## MOD5 SSD7348

### Response to Council submission on MOD5 - SSD7348, dated 9 September 2020

Drawing No.	Project No.	Issue
15-272-C2019	15-272	A3

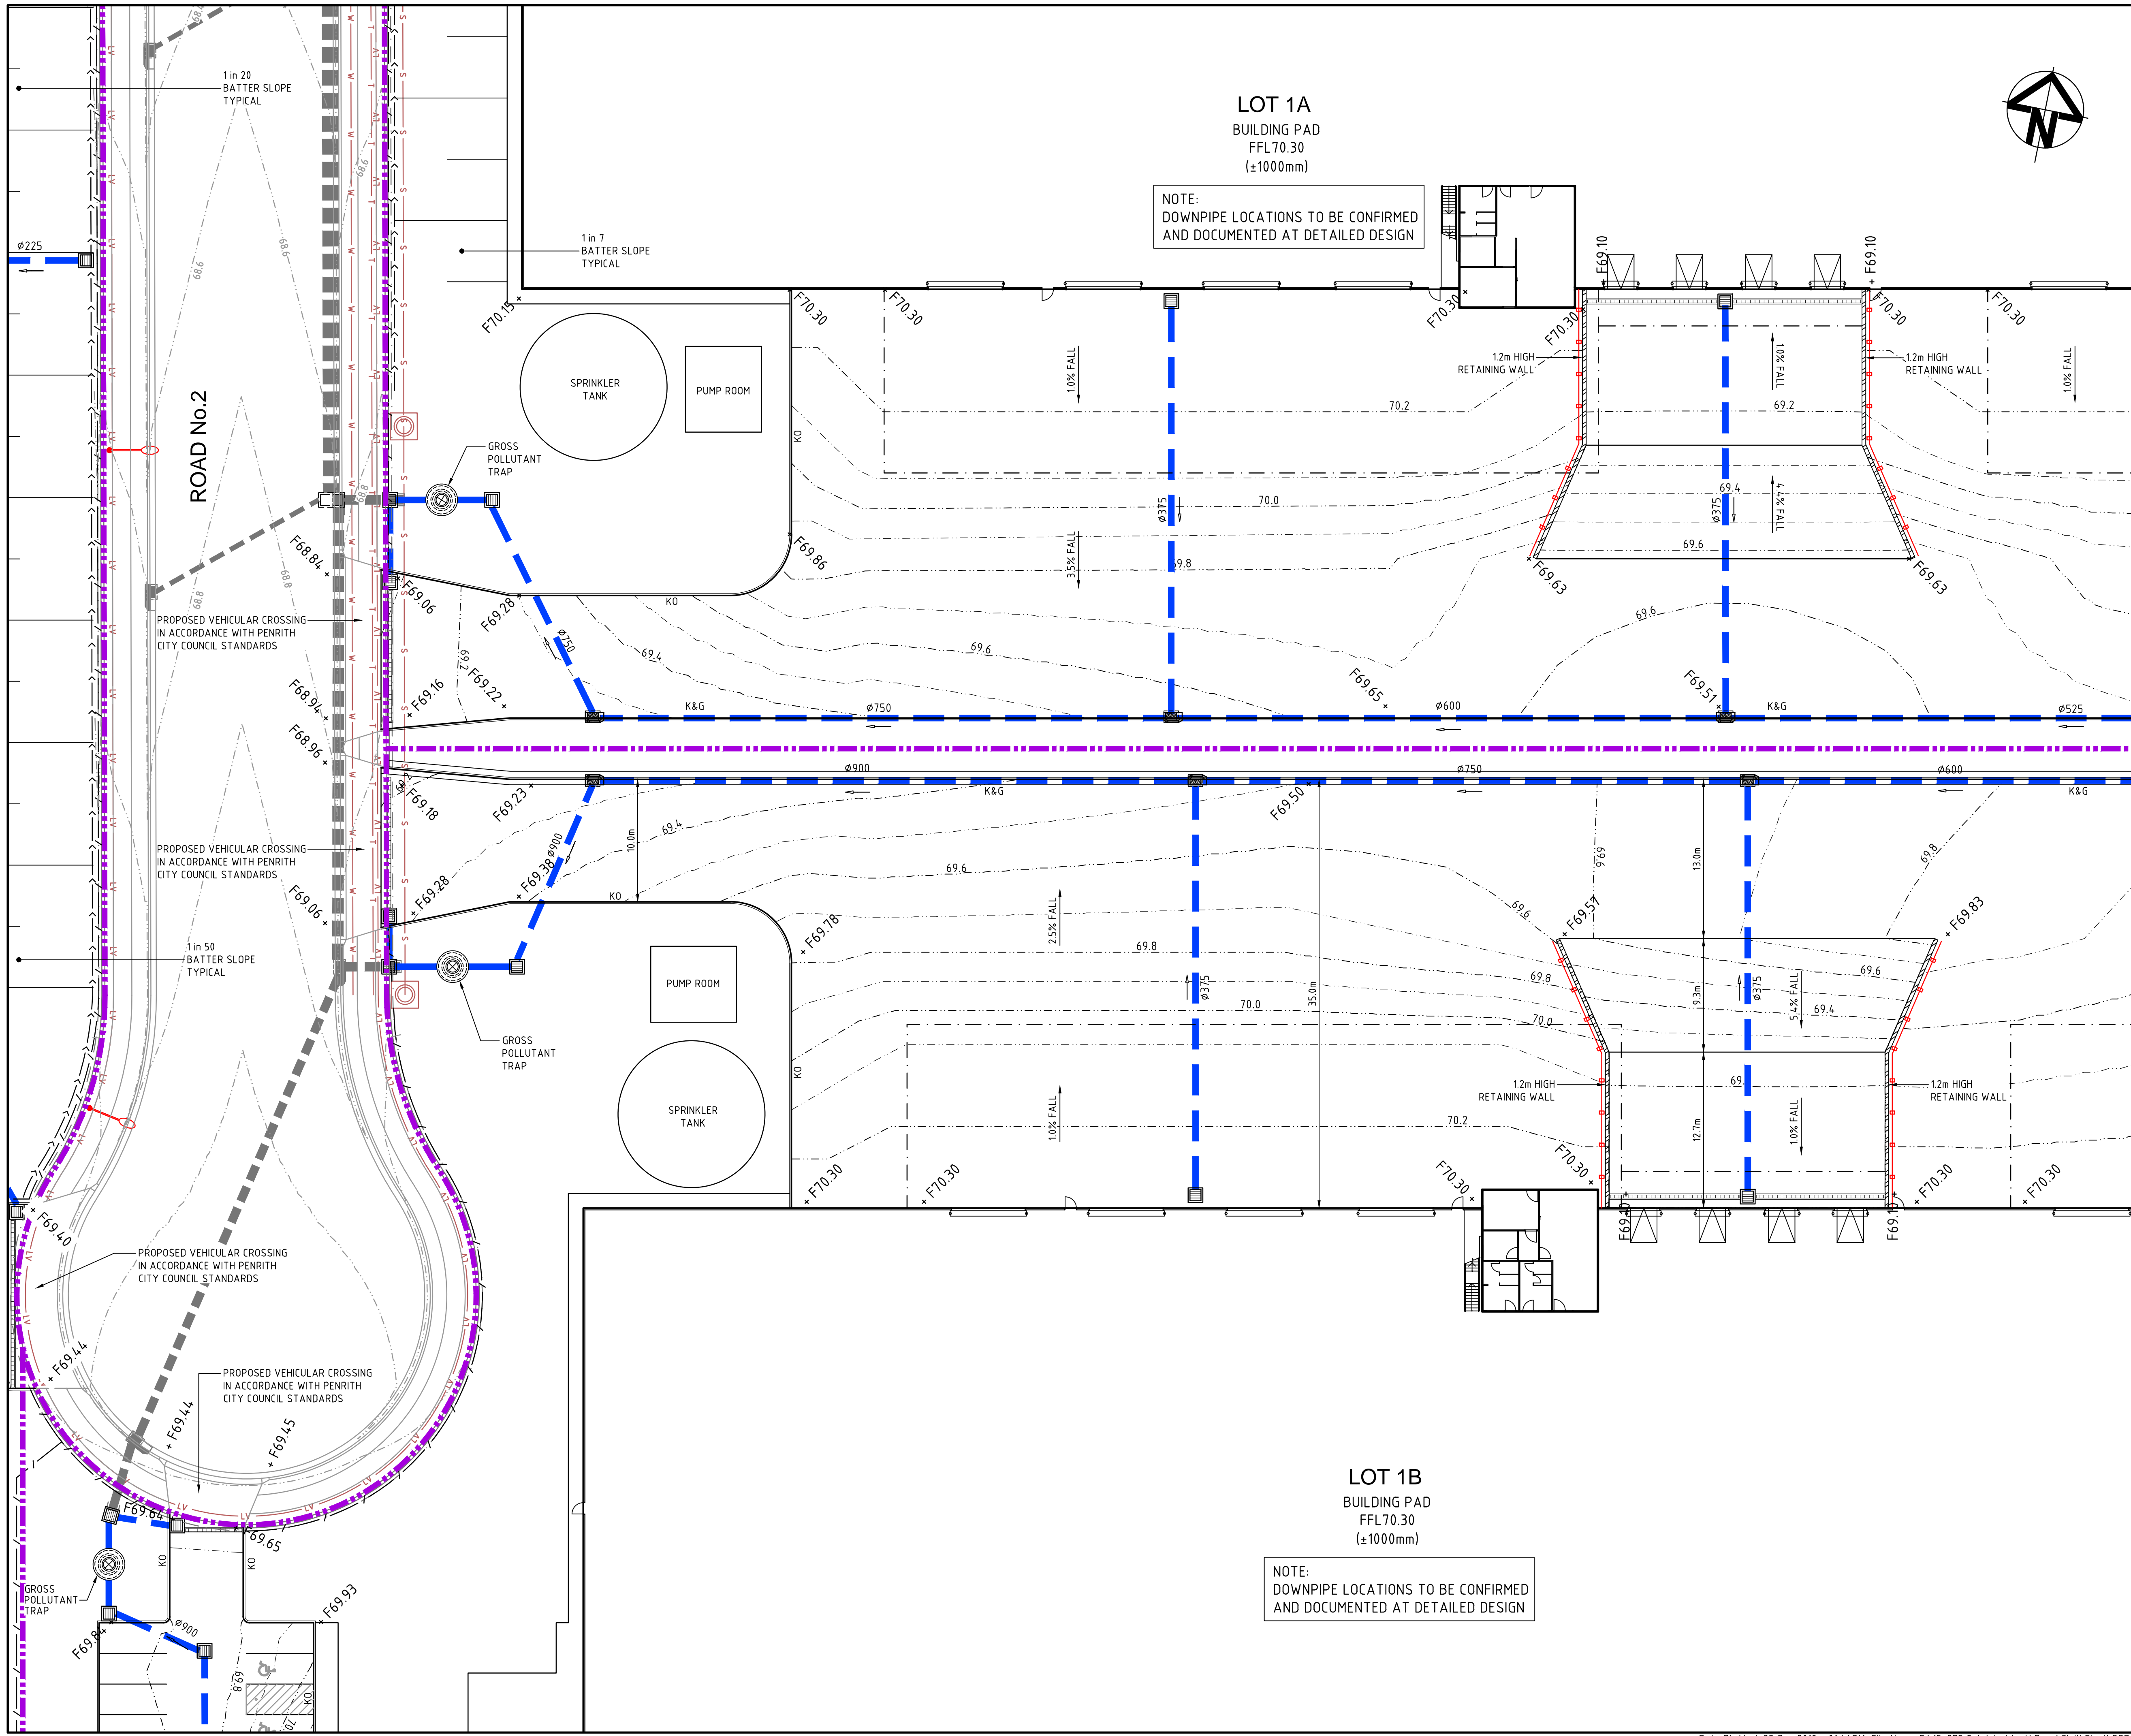
2) Where the SLR road reserve is widened into the batter adjoining the car park at the southern end of Lot 1A, the existing batter slopes of 1 in 3 will require either steepening or a retaining wall to support the SLR (sheets C2019 & C2020 – SLR slopes down to Lot 1A).

- Noted. Goodman does not propose to alter the levels which have already been approved.

Drawing No.	Project No.	Issue
15-272-C2023	15-272	A3

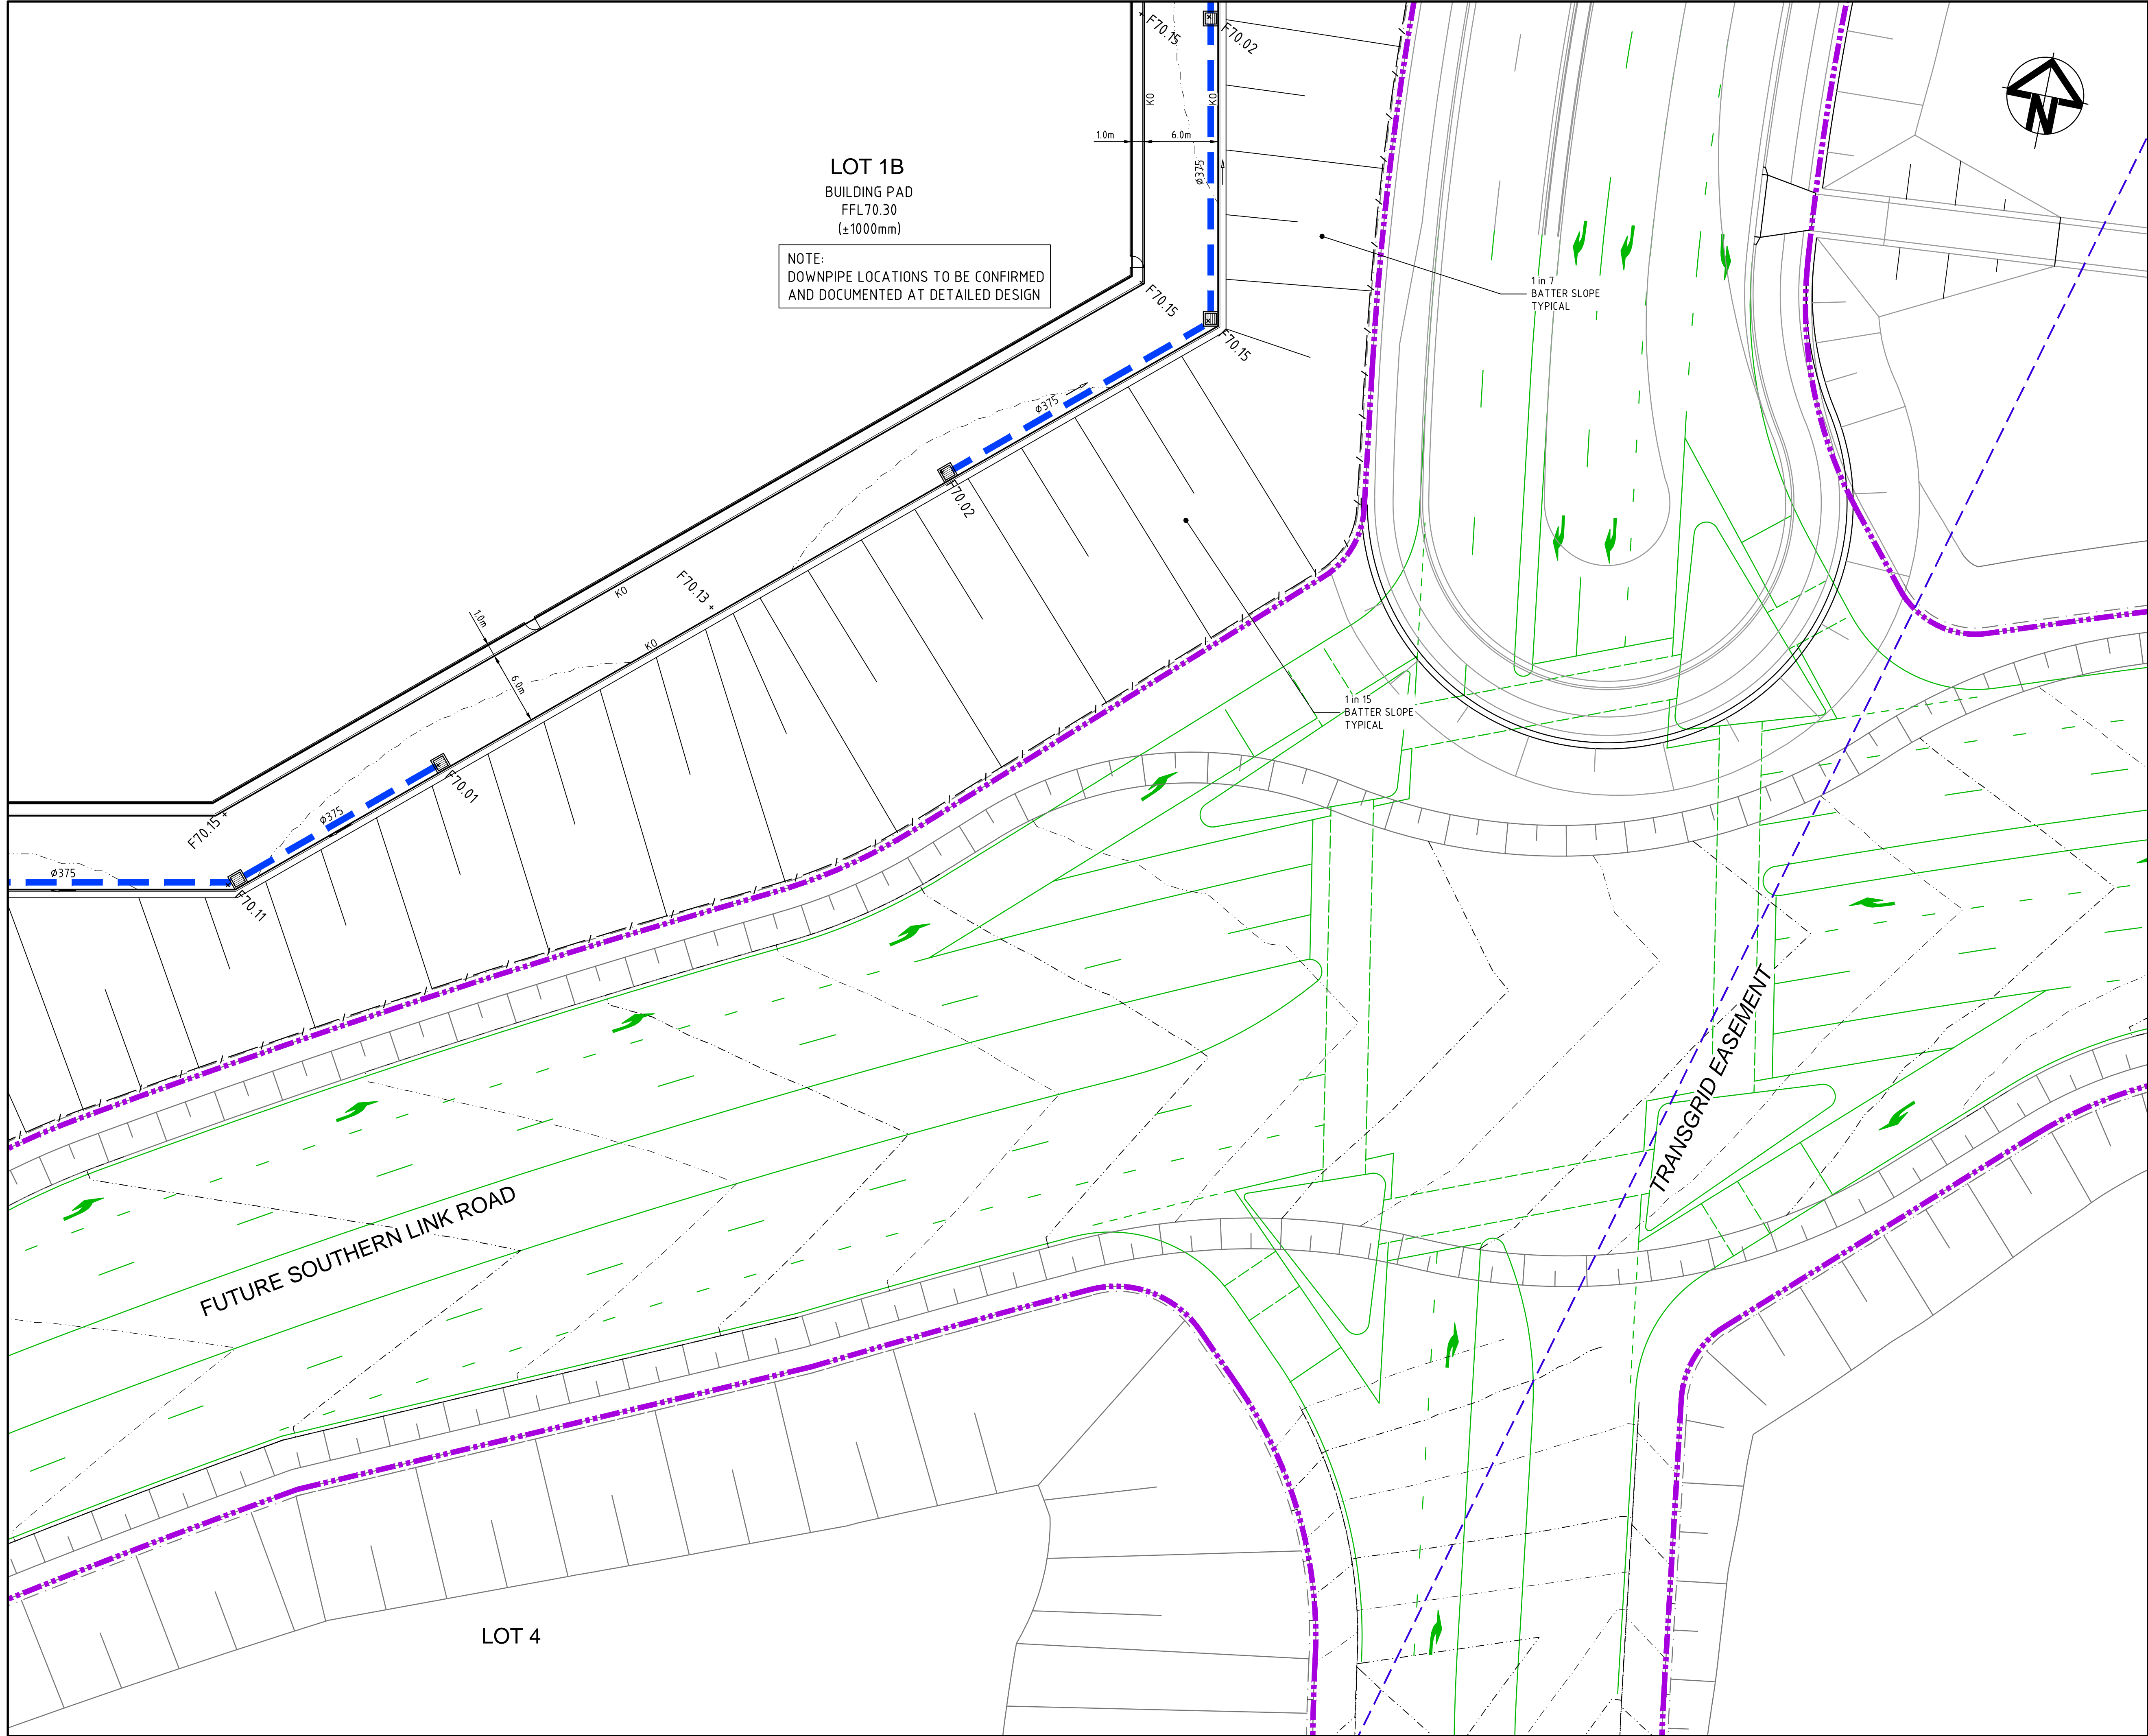
4) The widening of the SLR road reserve adjoining Lot 2B west of Road No 1 (sheets C2030 & C2023) will also impact batter slopes within this area. Details have not been provided.	<ul style="list-style-type: none"> <li>The subject subdivision has nothing to do with Lot 2B. The subdivision applications only affect 1A &amp; 1B-1C.</li> </ul>
The proposed plans submitted in support of the Mod 5 application, as a consequence of required changes to the proposed lot configurations, are not suitable and require further amendment due to further widening required by TfNSW. Noting that lot dimensions for road reservation widening is required, this widening cannot be at the expense of the landscape setback approved in the above SSD determination. Where the landscaping setback is impacted to less than the minimum 10m approved, reconsideration and amendment of the overall development arrangement is considered to be necessary.	<ul style="list-style-type: none"> <li>As mentioned above, TfNSW do not know which design option they will proceed with. Goodman suggest the application be approved as-is. Once TfNSW have approval to proceed with construction and the design is confirmed, the relevant authorities and parties can discuss how council's requirements are satisfied. Refer to <b>Annexure C</b>.</li> </ul>
